facsimile transmittal

To: Tim or Judy -- Mainewide **From:** Mike Nugent
Fax: 207-622-7528 **Date:** March 5, 2002
Phone: 800-452-1940 **Pages:** 1
Re: 110 Whitney Ave. 186A A018 **CC:** Mr. & Mrs Jones

Notes: In reviewing the permit for the above property, please forward the following details:

JOSEPH F. NEVILLE, P.E.
CONSULTING STRUCTURAL ENGINEER
404 Megquier Hill Road
POLAND, MAINE 04274
Phone/FAX (207) 998-4086

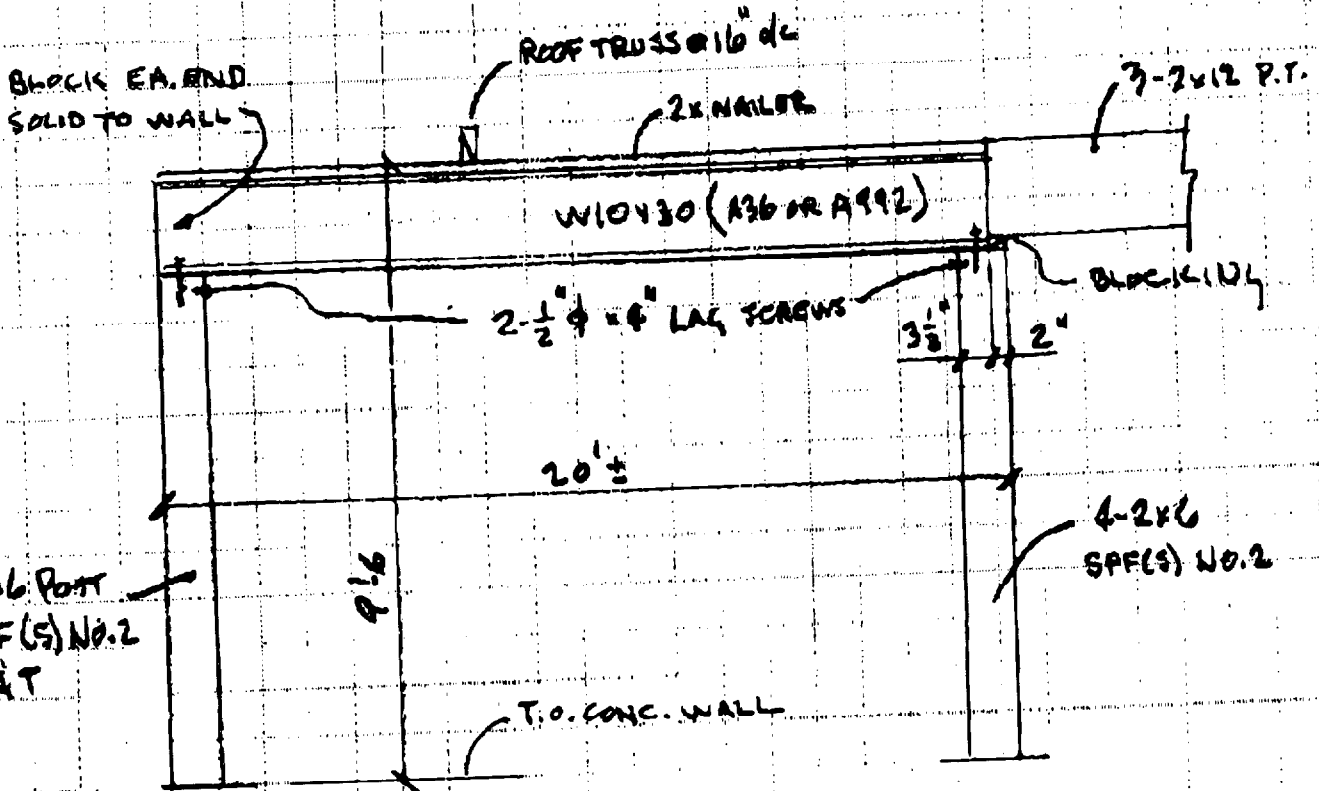
•
13. Structural Steel loading specs from the manufacturer and installation /framing detail.

ME WIDE CONSTRUCTION, INC.	
Scale: 1/4" = 1'-0"	Approved By:	Drawn By:	←
Date: 3-5-02	STEP CHAIR	Checked:	
Drawn By: J. TOWNS			
Address: PORTLAND, ME

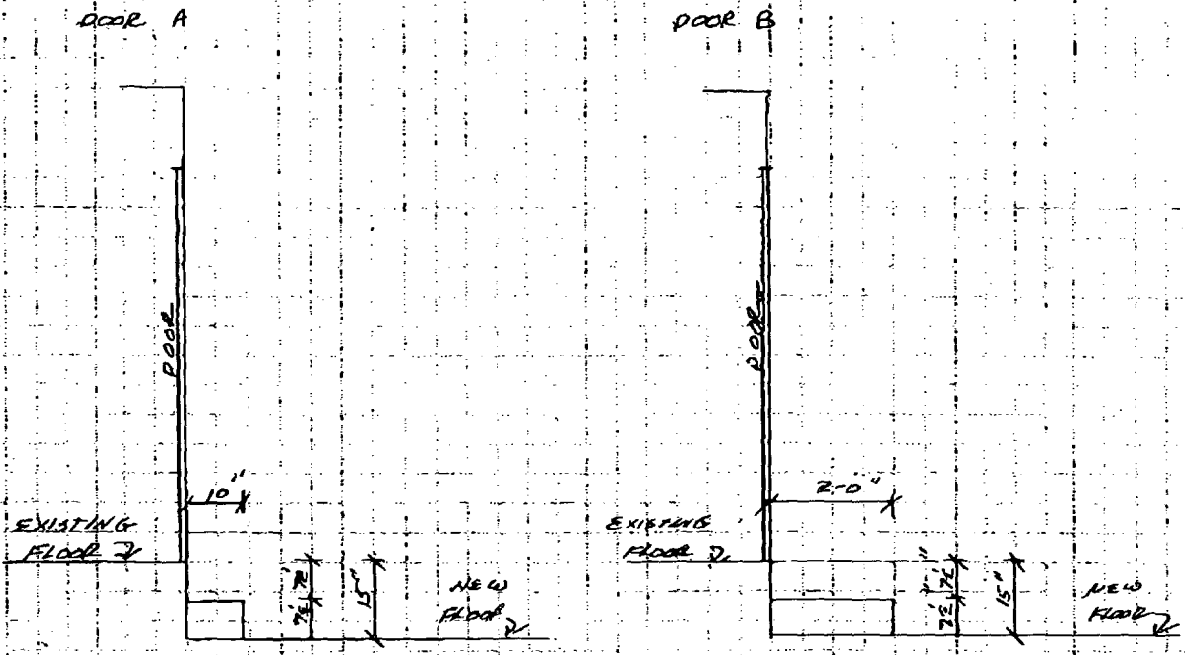
- 1. Footing Dimensions
- 2. Foundation wall thickness Foundation cross section
- 3. Size of anchor bolts
- 4. The 6" x 10" headers in the "open roof system" are under designed (See Table 502.5(1) in the 2000 I.R.C.
- 5. Step details from existing house
- 6. Header details where omitted
- 7. Egress window replacement schedule in existing house (Hardware included)
- 8. Electrical detail
- 9. Plumbing plan for "both rooms"
- 10. Foundation Drilling and Pinning detail
- 11. Steps stairs and landing details for the exterior doors.
- 12. Demo Permit Must be obtained prior to issuance of this permit due to lot coverage
